28 March 2014

**University of Sydney's Campus Improvement Program 2014-2020 State Significant Development (SSD 6123)**

01 ENGINEERING - SHEPHERD STREET ELEVATION PROPOSED

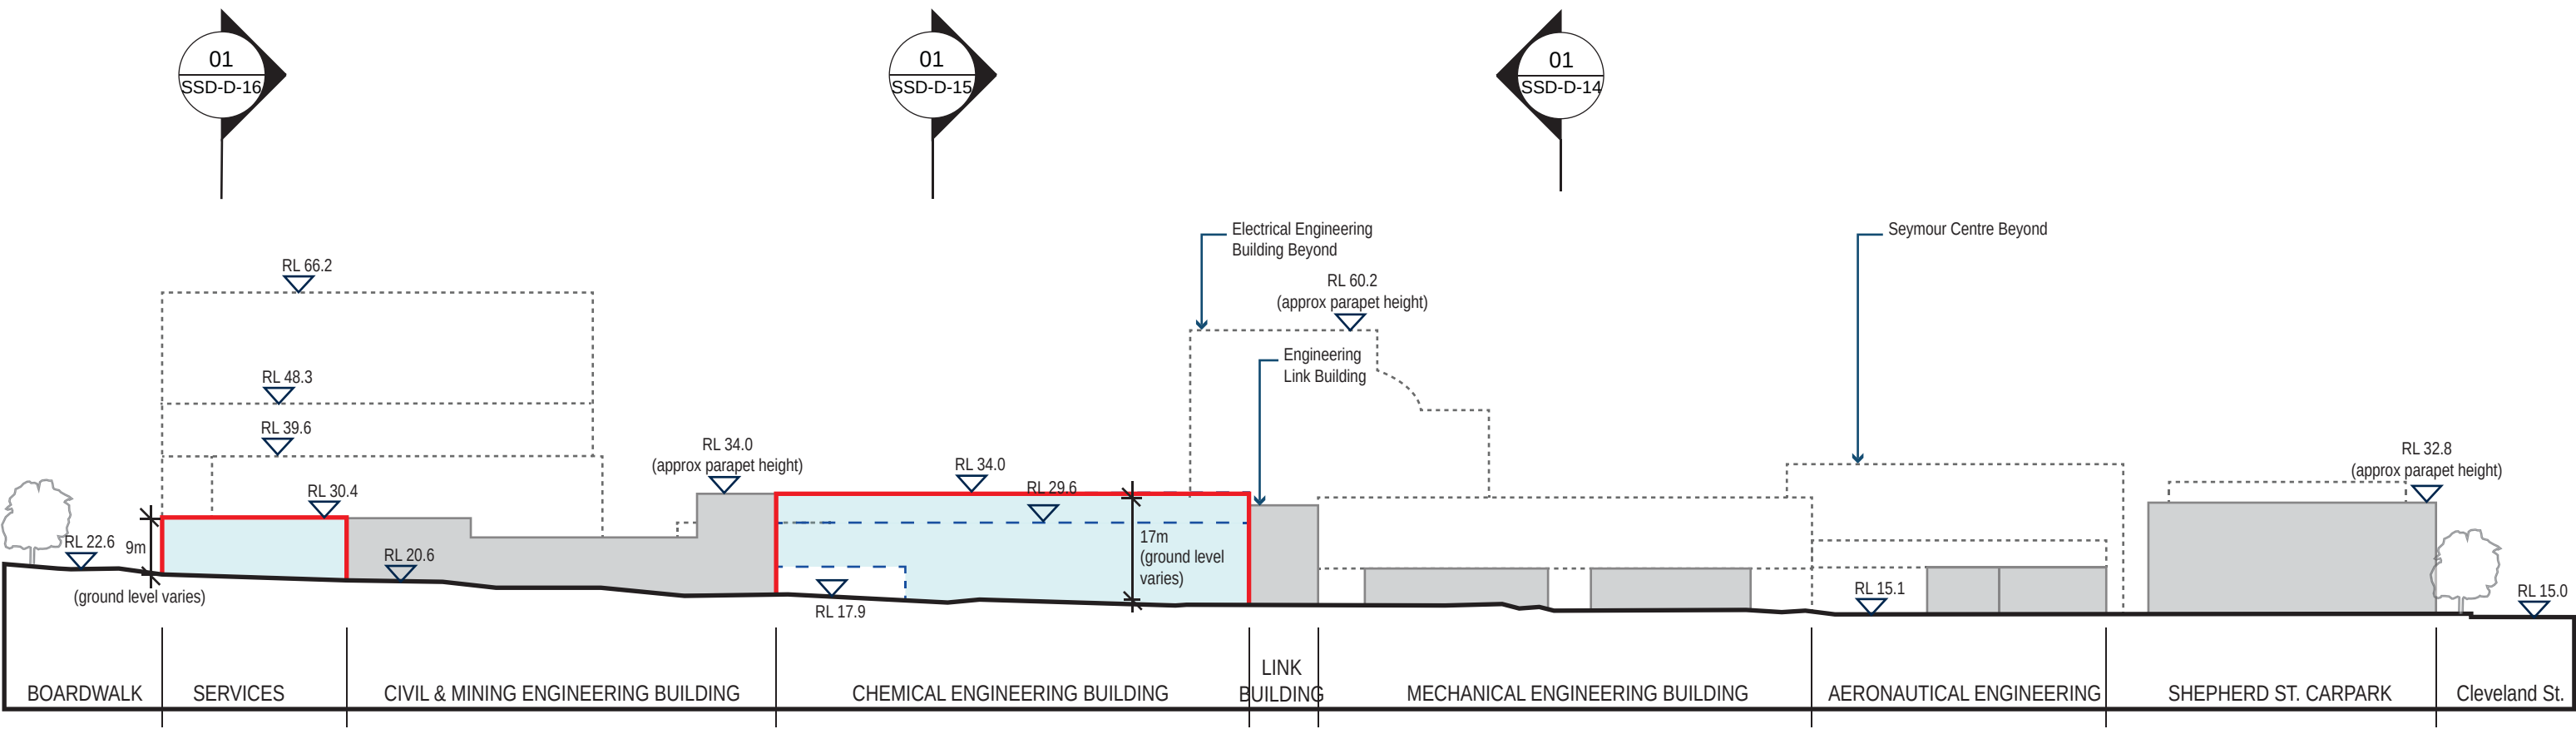
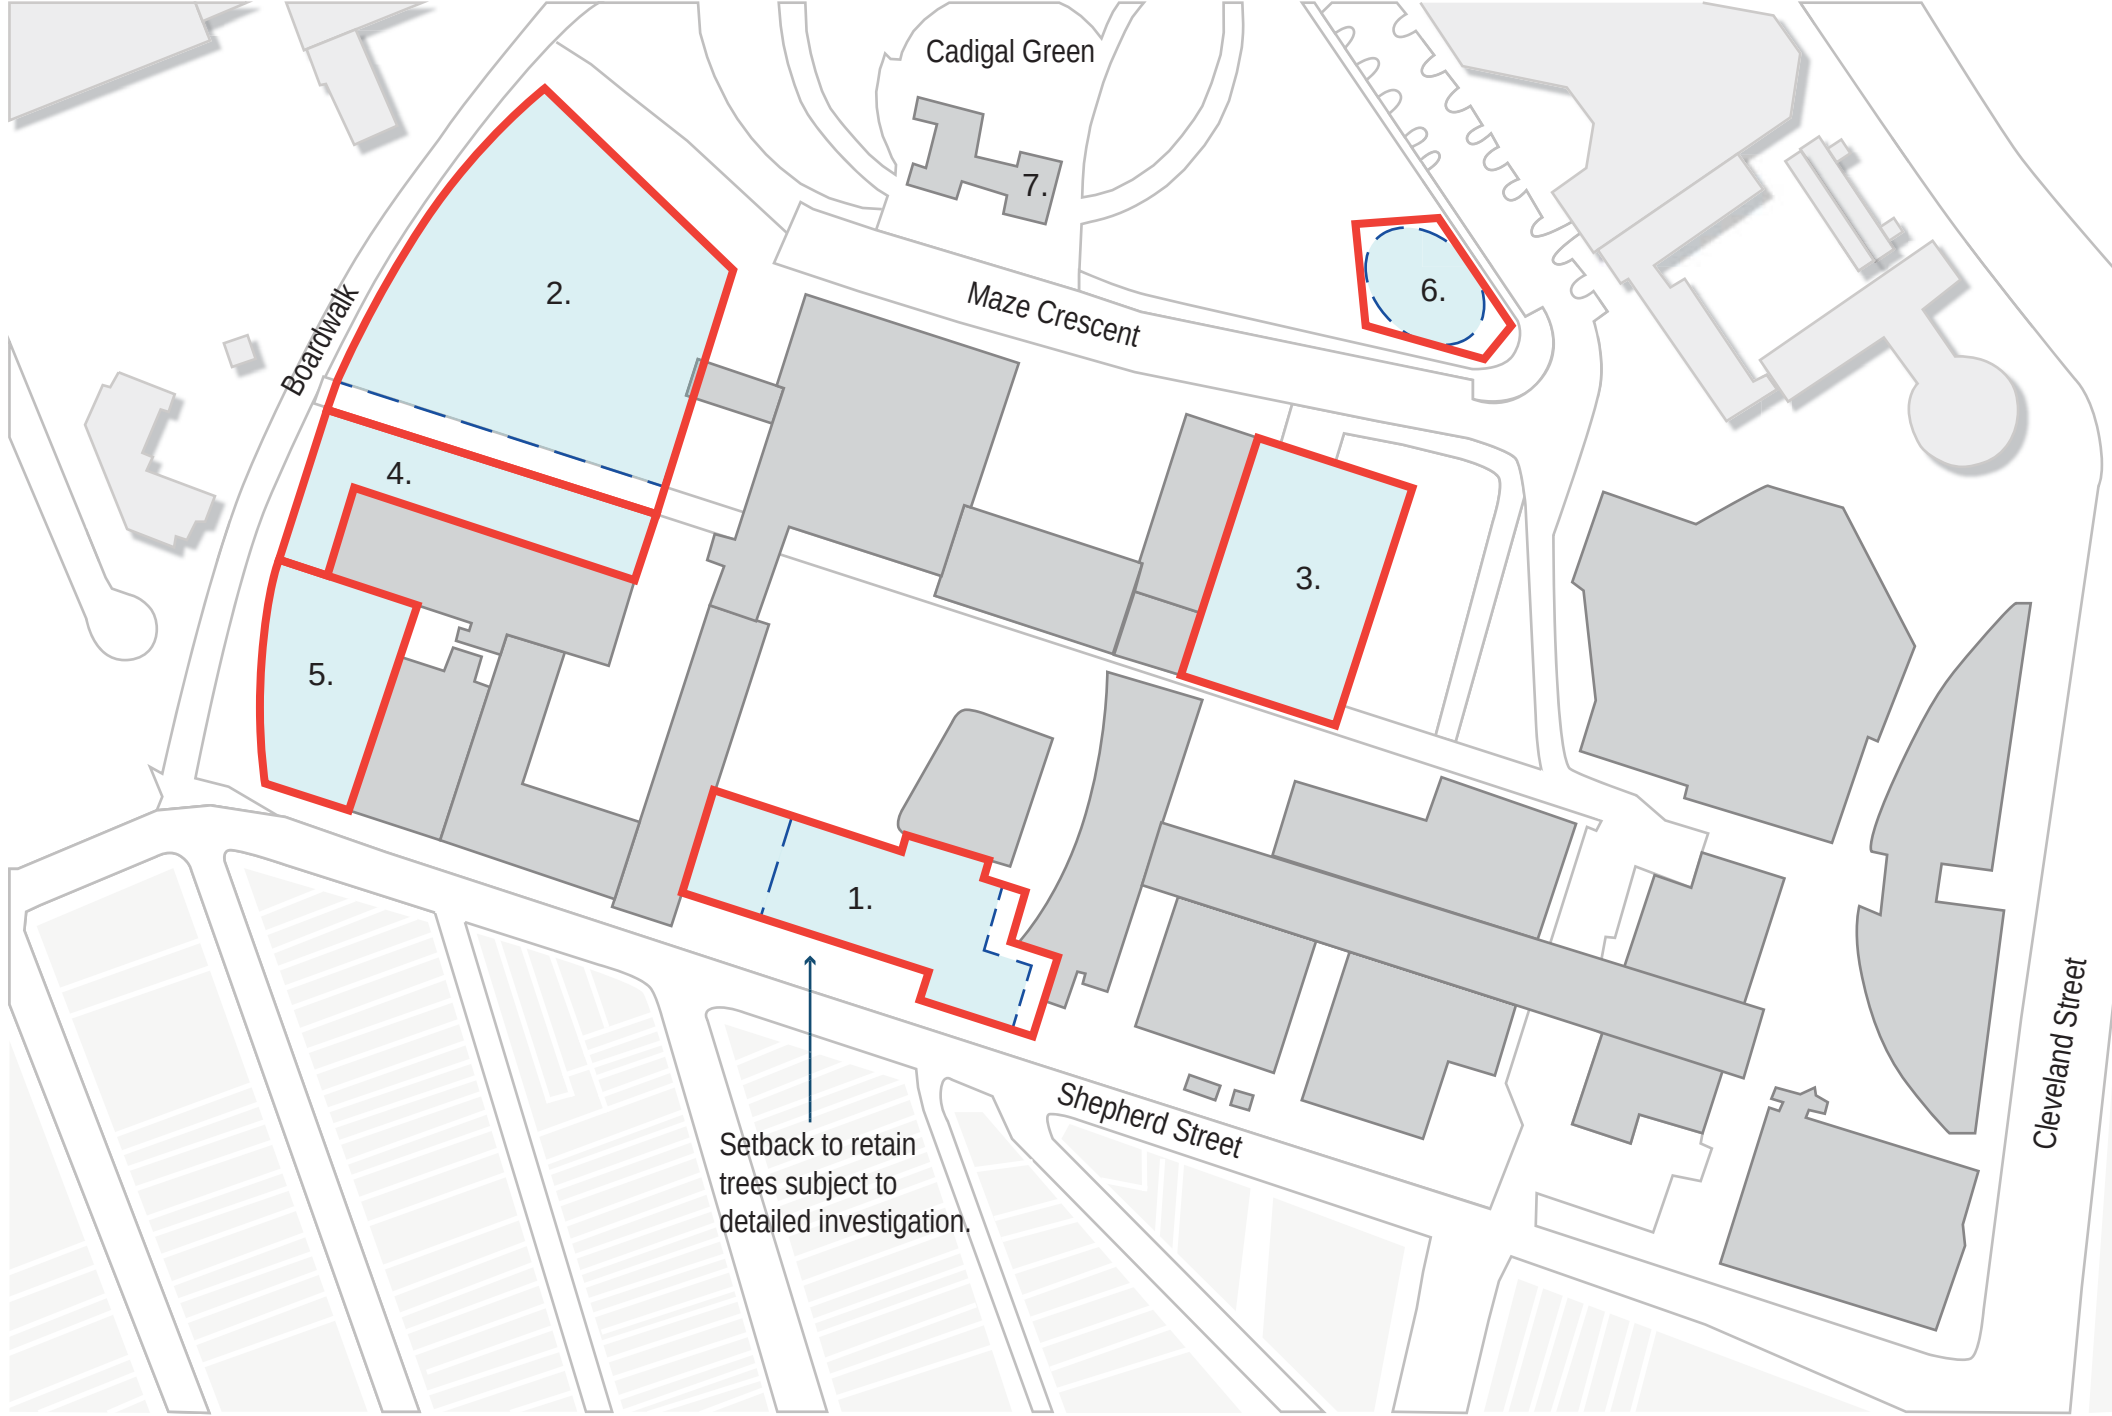
I object to the proposed 3 storey building in Shepherd Street and the "multidisciplinary building" opposite the Sports Centre both of which will overlook residents homes in Shepherd Street, Calder Road, Lander Street, Boundary Street and Abercrombie Street.

I object to the destruction of the Darlington Eucalypt Grove in Shepherd Street and replacing it with a 3 storey building overlooking residents' houses. This is one of the only remaining open spaces on the edge of the Darlington campus and should be retained to provide a green buffer zone between the University and the adjoining residential area.

I object to the proposed Service Centre on Shepherd Street as it will bring heavy, loud vehicles onto a residential street. As it will be positioned on the narrowest part of this street, it will also create a dangerous traffic hazard.

01 DARLINGTON TERRACES - DARLINGTON LANE ELEVATION PROPOSED

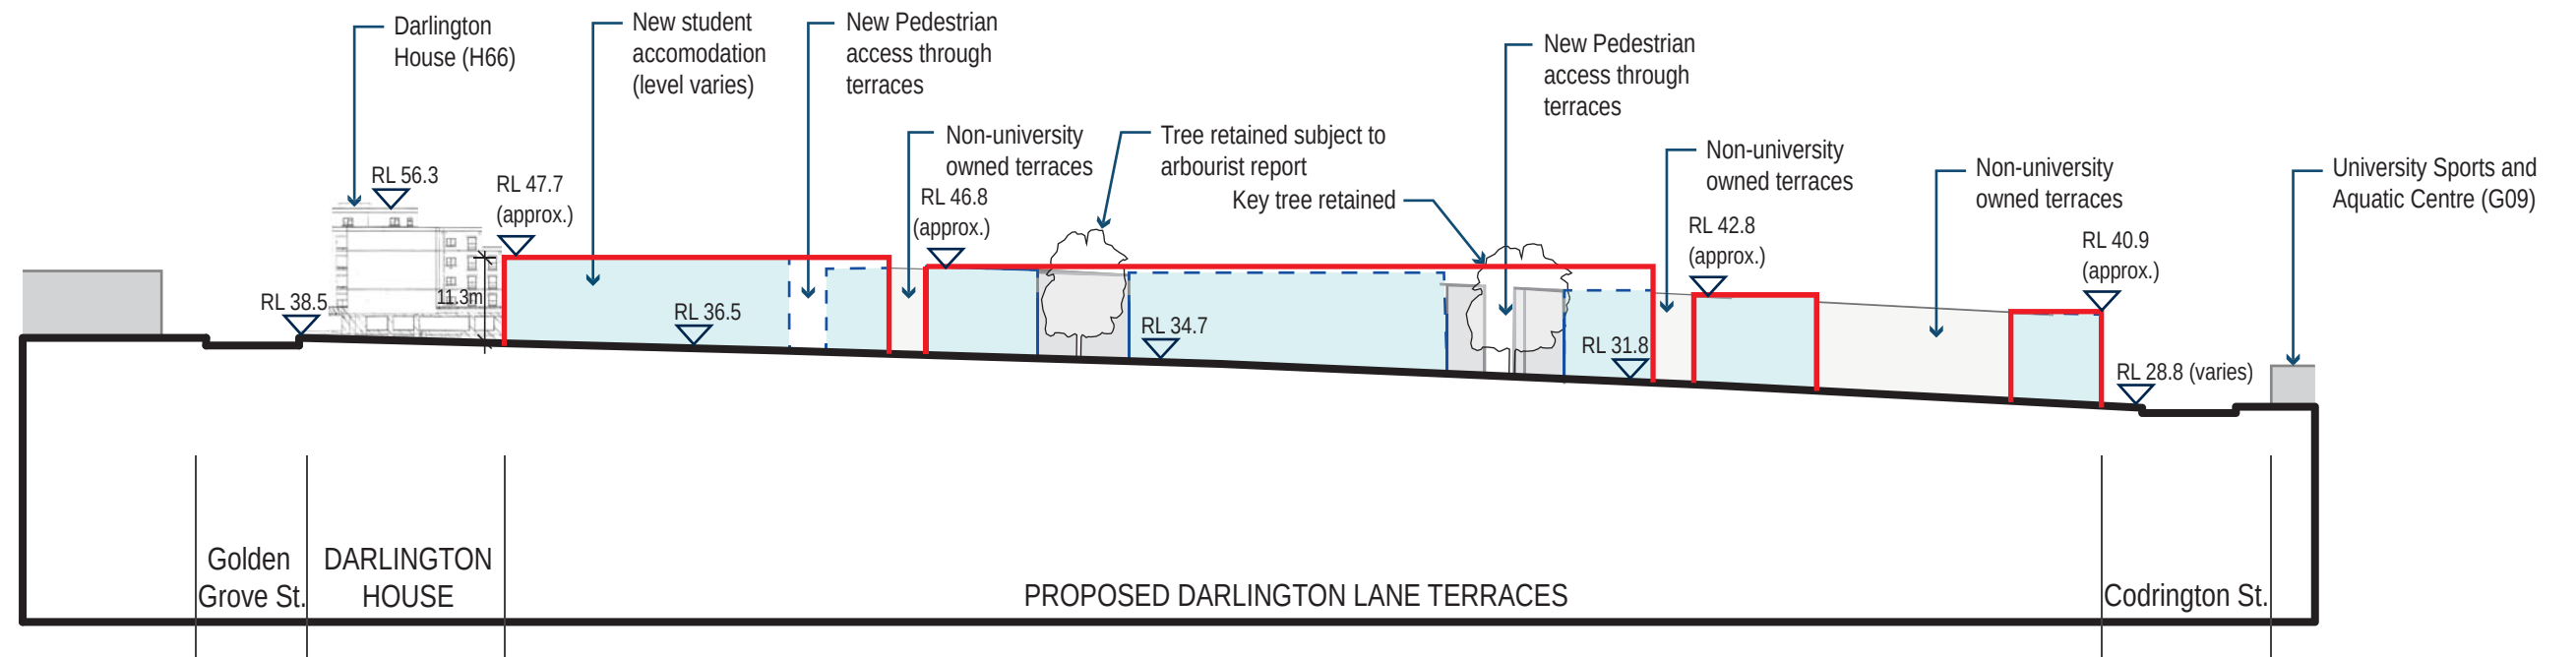
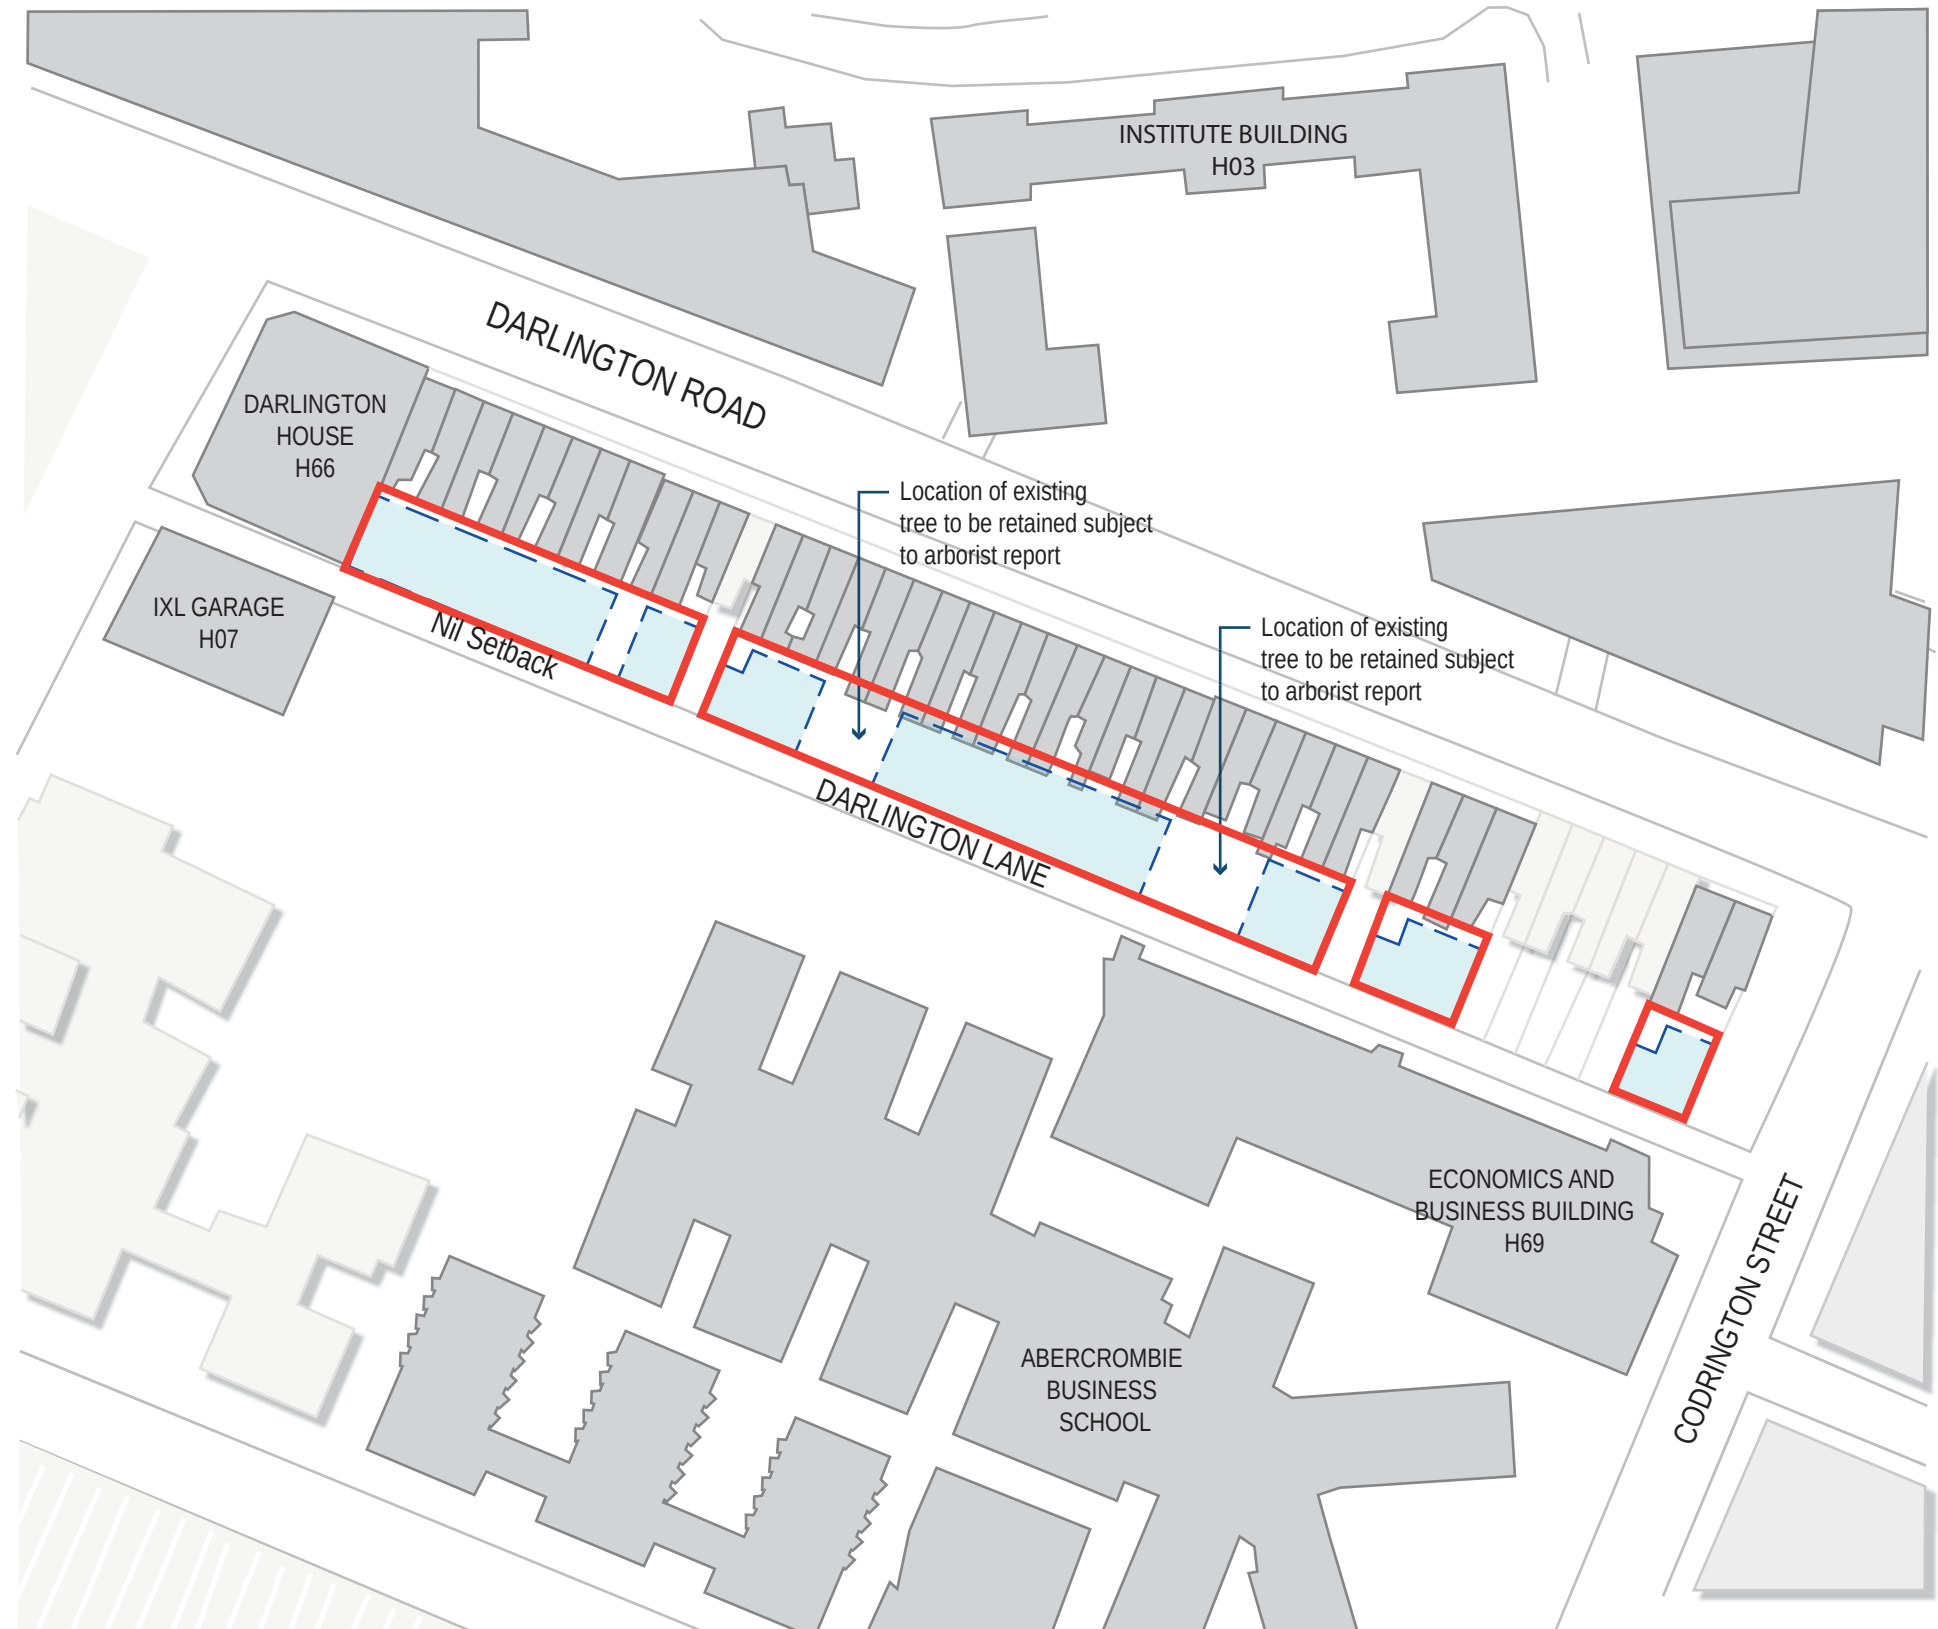
I object to the University's proposal to completely infill the backyards of every heritage listed terrace house (bar 3) from 86 – 130 Darlington Road with 3 storey extensions.

The National Trust has given these terraces an "A" rating – "highly intact". The University should not be allowed to degrade the heritage value of these terraces which are very close to the Golden Grove Conservation Area.
